CITY OF ALBUQUERQUE

Re: Certification Submittal for a Permanent Certificate of Occupancy for
Snow Heights Commercial Shopping Center
11001 Menaul Blvd N.E.
Engineer's Stamp dated 09-17-12 (H-21/D043)

**Re: Snow Heights Commercial Shopping Center, 11001 Menaul Blvd NE,
Request for Permanent C.O. –Accepted
Engineer's Stamp dated: 07-21-11, (H21/D043)
Certification dated: 09-06-12**

**Re: Snow Heights Commercial Shopping Center
Grading and Drainage Plan
Engineer's Stamp dated 7-21-11 (H21/D043)**

ENGINEER'S SEAL RONALD R. BOHANNAN P.E. #7668	FOOTHILLS, S.C. MENAU AND JUAN TABO	DRAWN BY DY
	AA - SITE PLAN FOR BUILDING PERMIT (OVERALL)	DATE 9-02-11
 5571 MIDWAY PARK PL NE ALBUQUERQUE, NEW MEXICO 87109 (505) 858-3100 www.tierrawestllc.com		DRAWING 2010077-SPB
		SHEET # 1
		JOB # 2010077

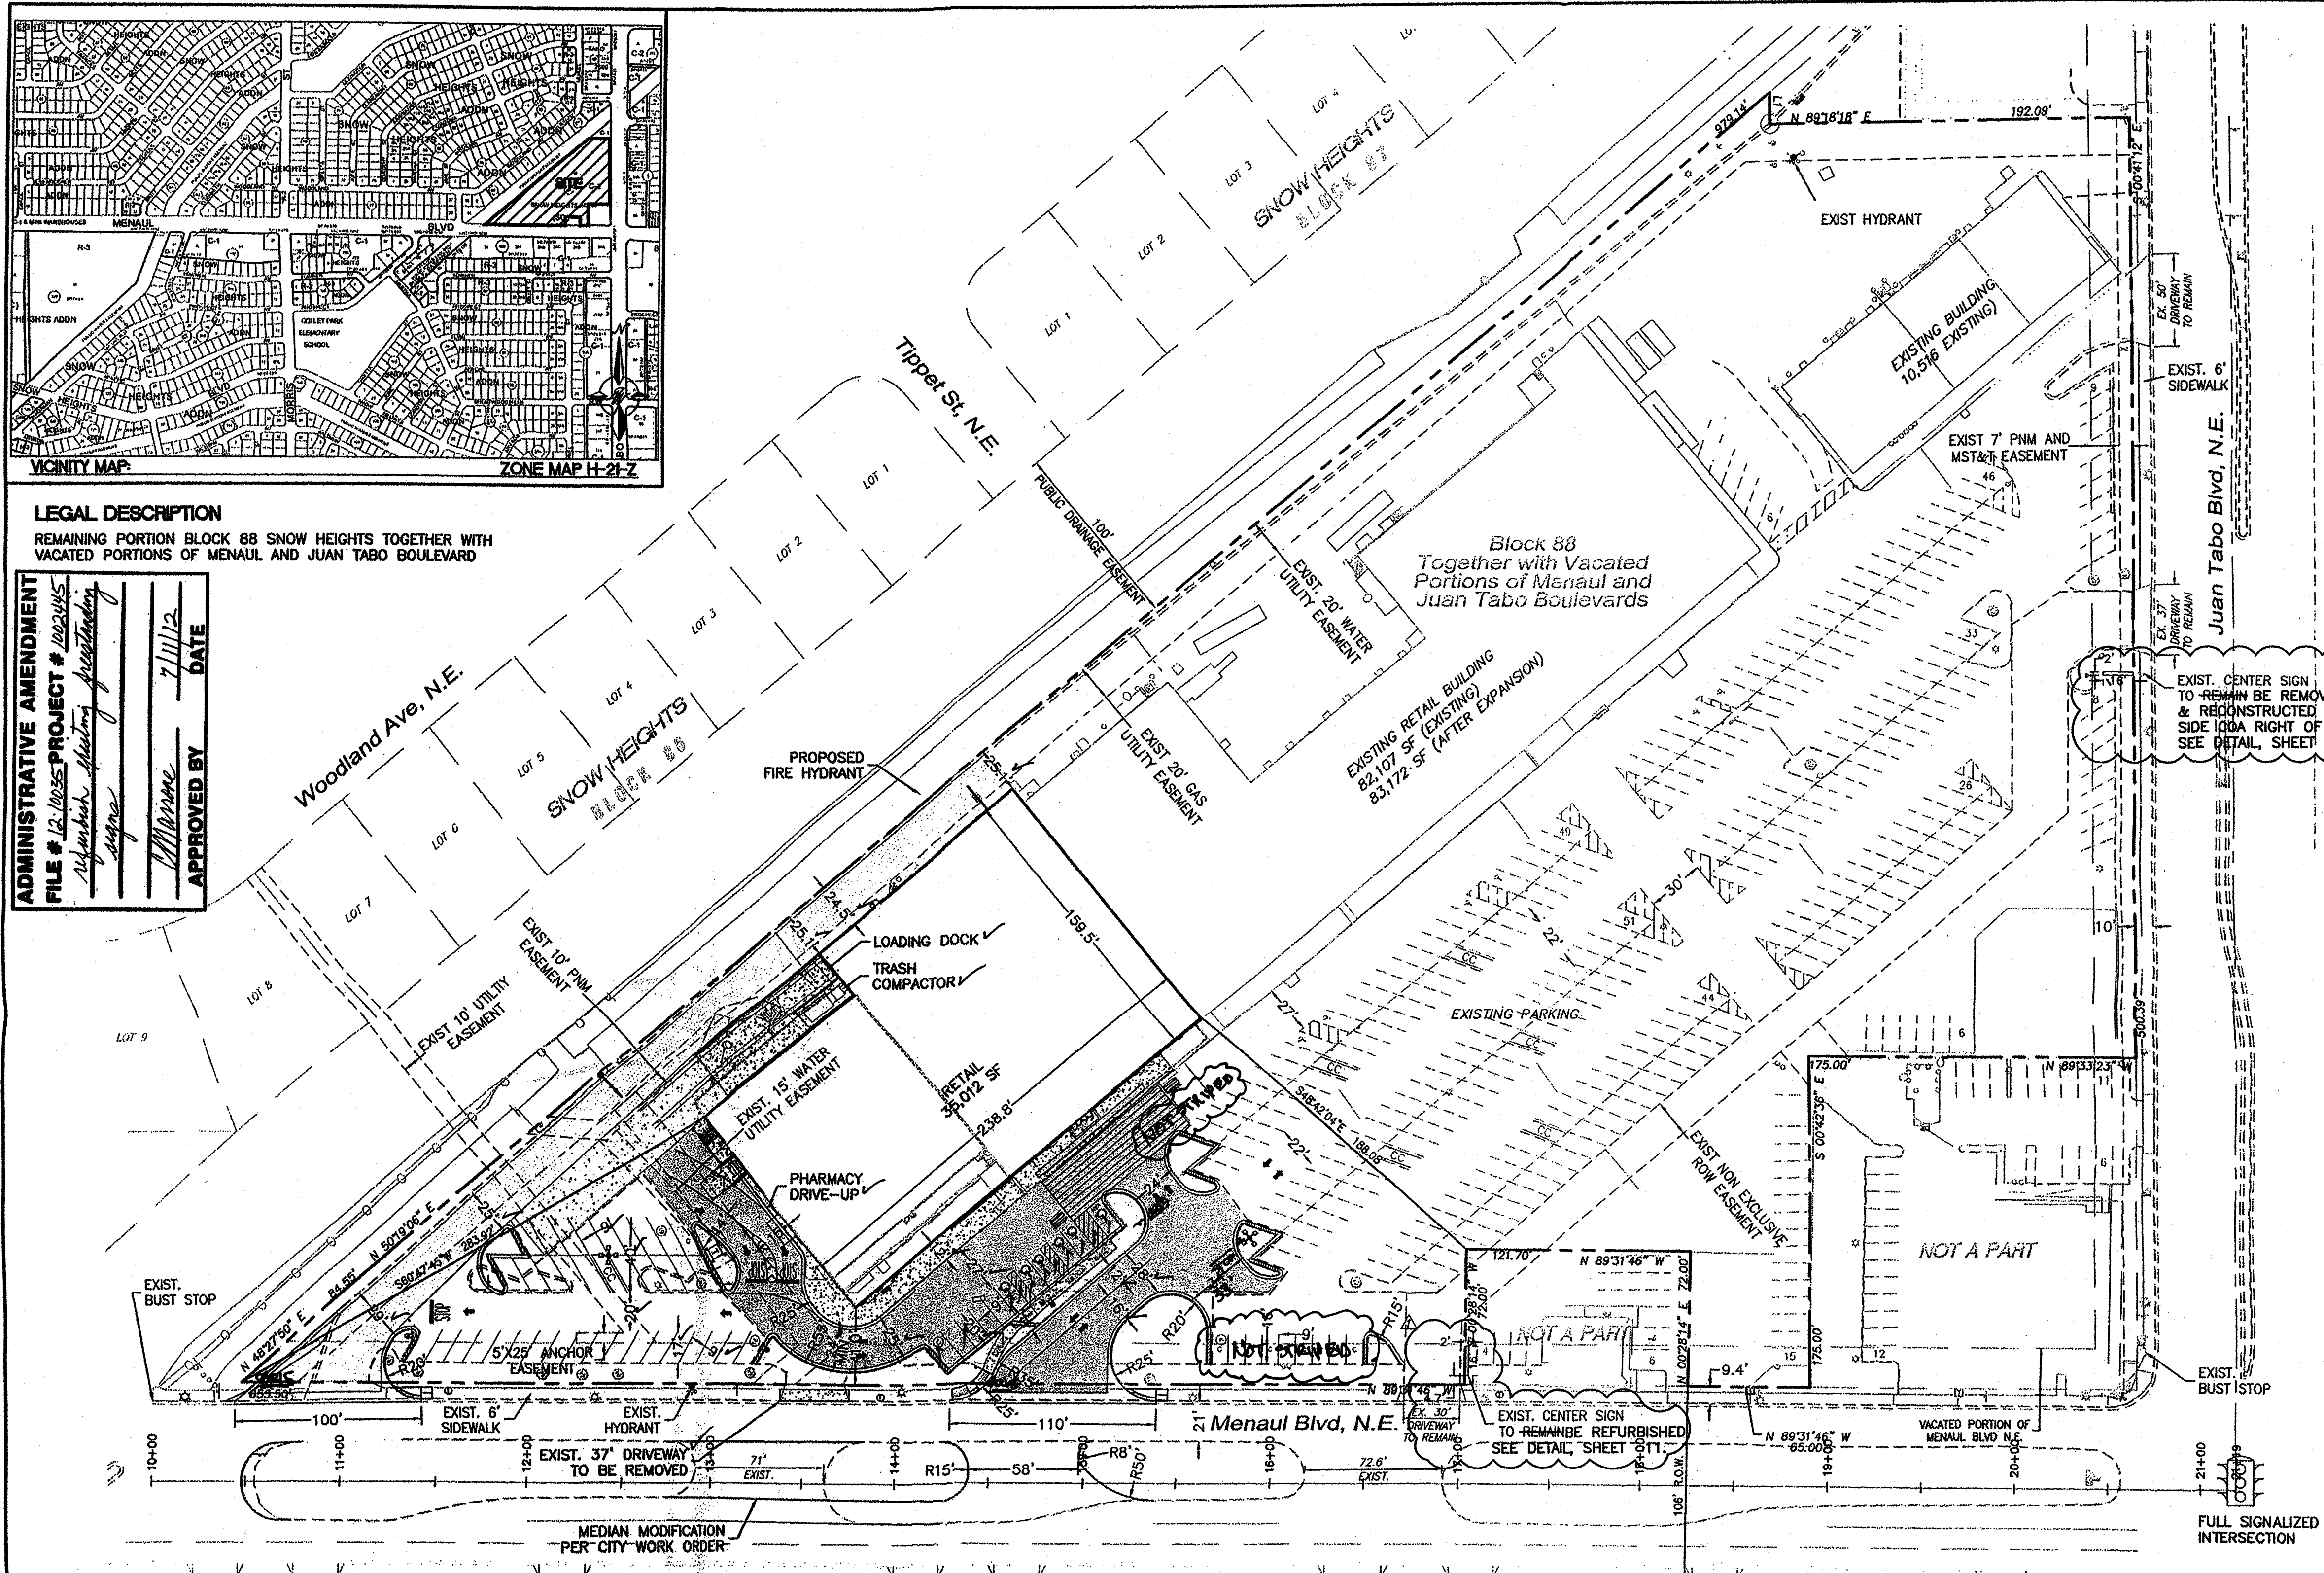
- Comment: Need to provide 8-foot wide van accessible aisle instead of 5-foot access that has been provided for all van accessible stalls.*
Response: Van accessible spaces were striped 11-foot wide (132 inches) with a 5-foot (60-inch) access aisle, as required by the 2010 ADA.
- Comment: All striping will need to be completed and all equipment removed from site.*
Response: We have verified all striping has been completed and all equipment removed from site during our site inspection.
